# Appeal Decision

**Appeal Ref: APP/R5510/D/23/3322181**

**11 Court Road, Ickenham, Hillingdon UB10 8TF**

- The application sought planning permission for part single: part two storey side and rear extension (following part demolition of side extension) without complying with a condition attached to planning permission Ref 76354/APP/2021/3284, dated 22 October 2021.

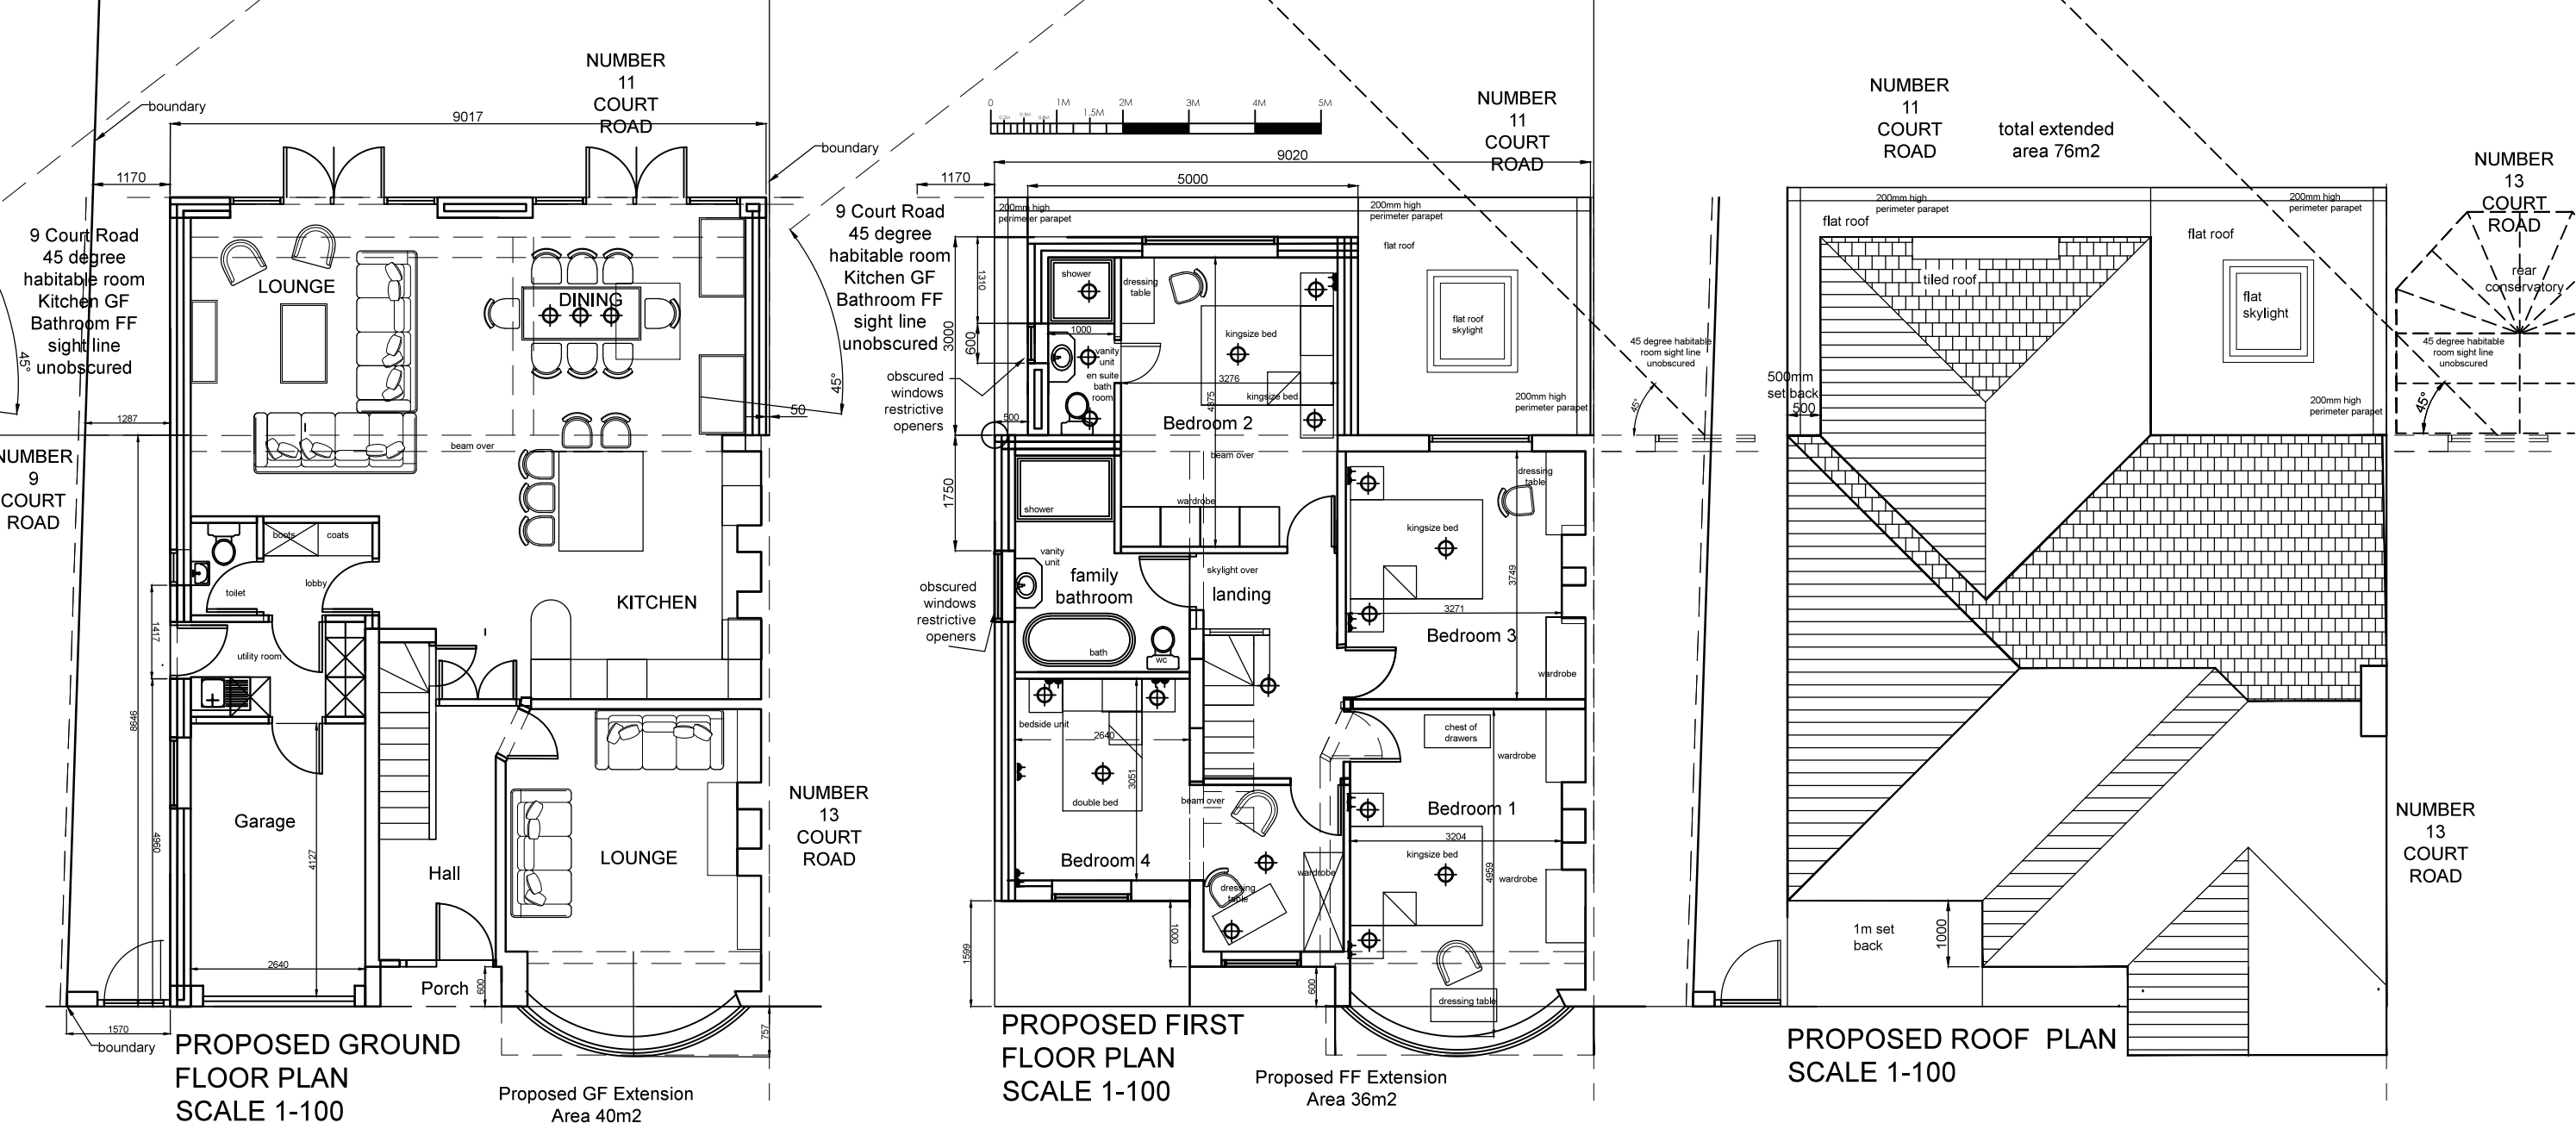
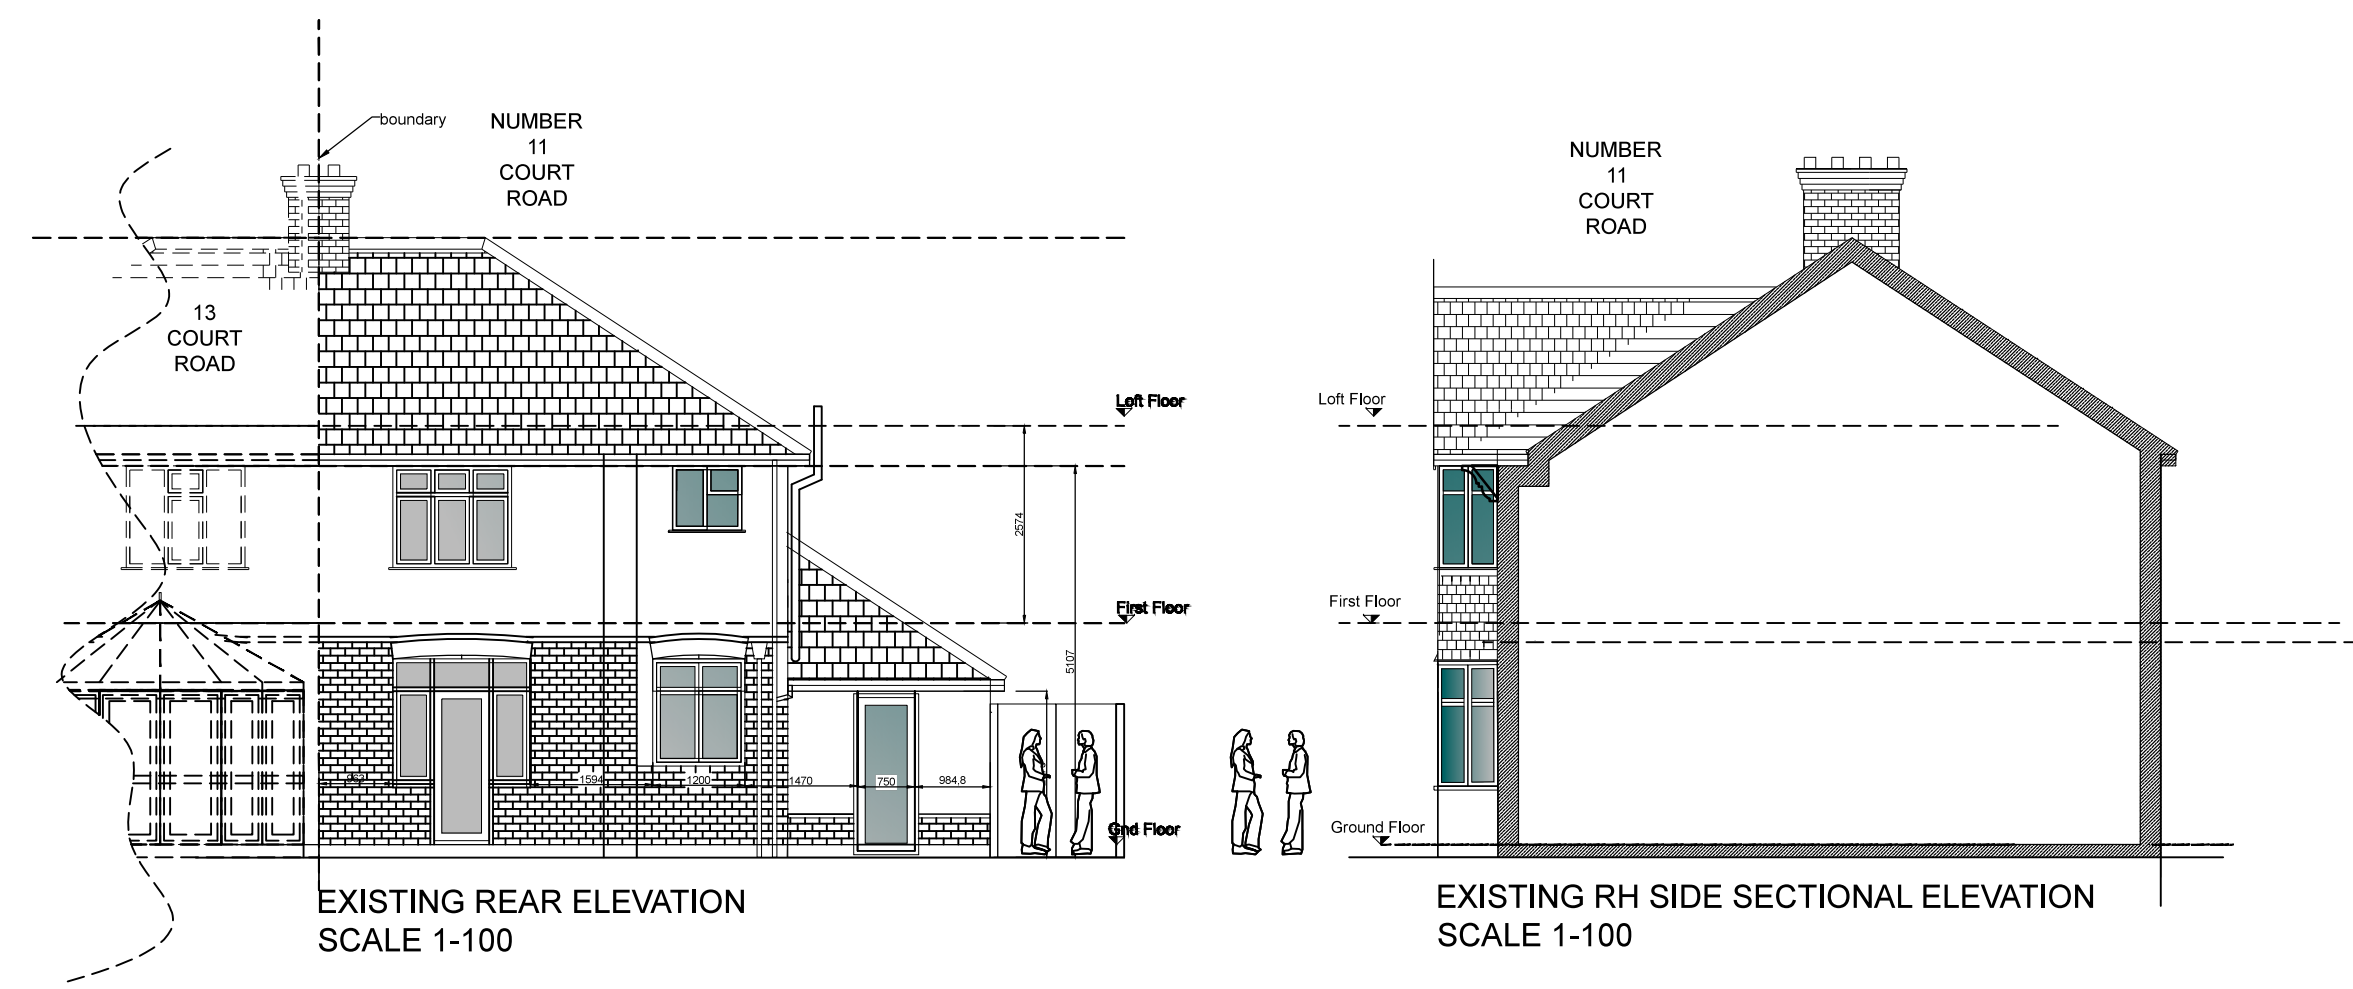
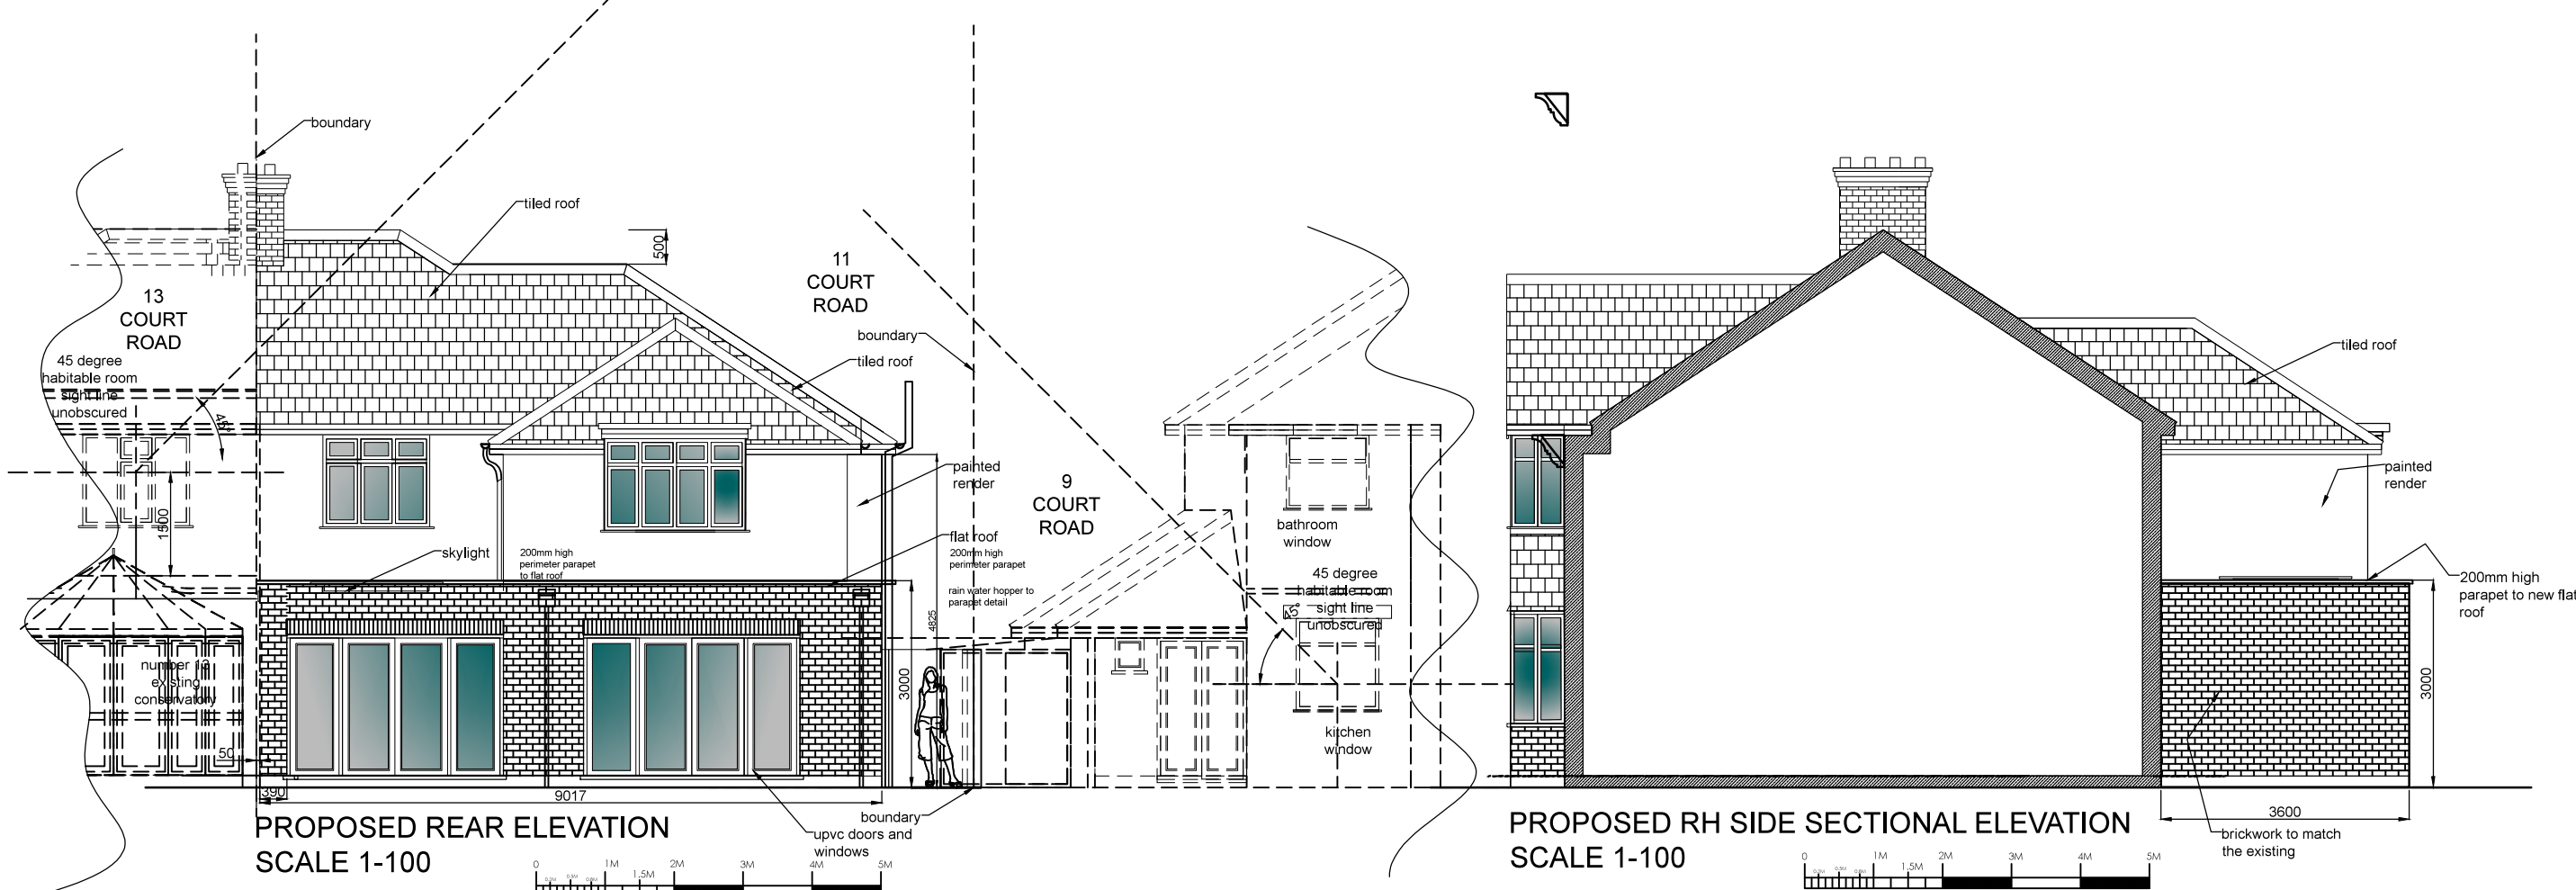
3. The approved works have been completed, including the installation of bathroom and en-suite windows at first floor level of the northern flank elevation facing No 9 Court Road (No 9). The location of the windows is consistent with the approved drawings and they are obscurely glazed. However, the lower part of the windows are openable, contrary to the requirement of Condition 7. They are fitted with restrictors. Following an enforcement complaint, the appellants were invited to retrospectively apply for consent for the windows as installed as a variation to the requirements of Condition 7. That application was refused planning permission and is now the subject of this appeal.

4. The restrictors limit the degree of opening of the windows to about 5cm at the bottom edge. There are constrained and narrow views out from the bottom and along the sides of the windows when they are opened which do not amount to overlooking. The depth of their internal window sills and the location of the bathroom fittings physically prevent looking out of these windows through the small openings. As a result, there is no harmful overlooking of the neighbouring amenity space. From my observations, it would not be possible to override the restrictors.

5. I agree with the Council that full opening of the windows would result in direct and harmful overlooking of the main outdoor amenity space of the neighbouring property. It is therefore reasonable and necessary to impose a replacement condition to permanently retain the restrictors on each of the windows as they prevent any overlooking. Such a condition would enable the Council to take any necessary action in the event that the current or future owners or occupiers of the property enabled the windows to fully open. Accordingly, there would be continued compliance with Policy DMHB 11 of the Hillingdon Local Plan Part 2 (2020).

1. The appeal is allowed and planning permission is granted for part single: part two storey side and rear extension (following part demolition of side extension) at 11 Court Road, Ickenham, Hillingdon UB10 8TF in accordance with the application Ref 76354/APP/2023/451, dated 16 February 2023, without compliance with condition No 7 previously imposed on planning permission Ref 76354/APP/2021/3284, dated 22 October 2021 and subject to the following condition:
  - 1) The first floor bathroom and ensuite windows in the elevation facing No.9 Court Road shall remain glazed with permanently obscured glass to at least scale 4 on the Pilkington scale (or the nearest equivalent standard) and shall have a restricted opening system allowing a maximum opening of 5cm. The windows shall be retained in that form thereafter.

6. For the reasons given above and having regard to all other matters raised, I conclude that the appeal should be allowed with a varied condition requiring the subject windows to remain obscurely glazed and their opening restricted, in order to protect the privacy of neighbouring residents. As the development is substantially complete, there are no remaining conditions from the original permission that need to be reimposed.
